# Pre-app advice

75 The street, Manuden  
Proposed rear extension

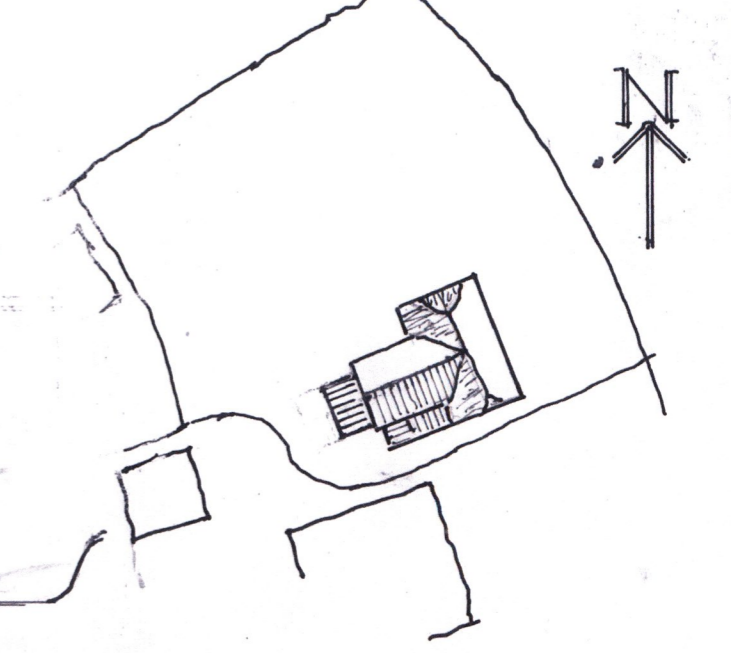
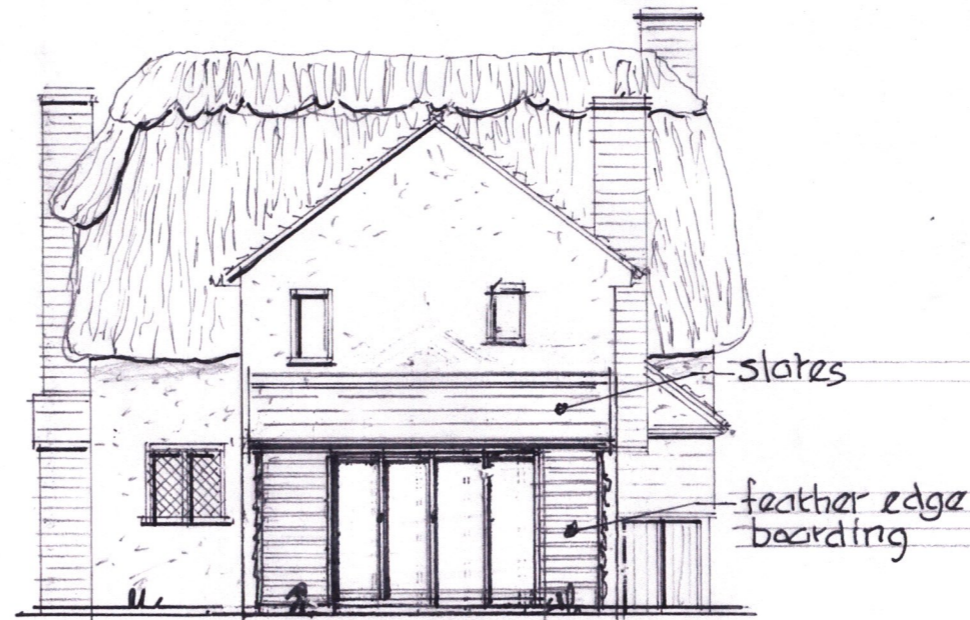
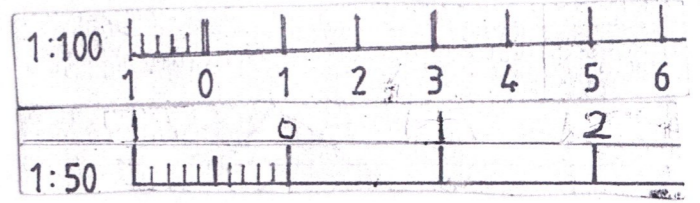
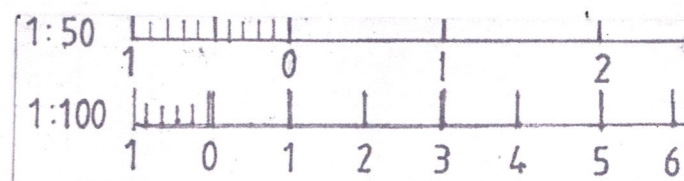
With regards to the proposed rear extension it is understood that the proposed location is upon a modern rear two storey extension thus no historic fabric will be impacted which is a positive. Careful consideration must also be given to avoiding the cumulative impact of later additions to the listed building and its historic core. The significance of the listed building is that of a modest rural dwelling and any extensions or additions should be subservient to the host.

The proposed rear extension is to be a single storey lean-to addition, approximately 2m in depth, with clay tiles to match the existing, timber weatherboarding and timber windows. It is considered that a modest extension as proposed would not result in harm to the significance of the listed building and the proposed materials are considered acceptable. With regard to the design, it is suggested that this should be of a utilitarian appearance with casement windows however, there is no objection in principle to a contemporary approach.
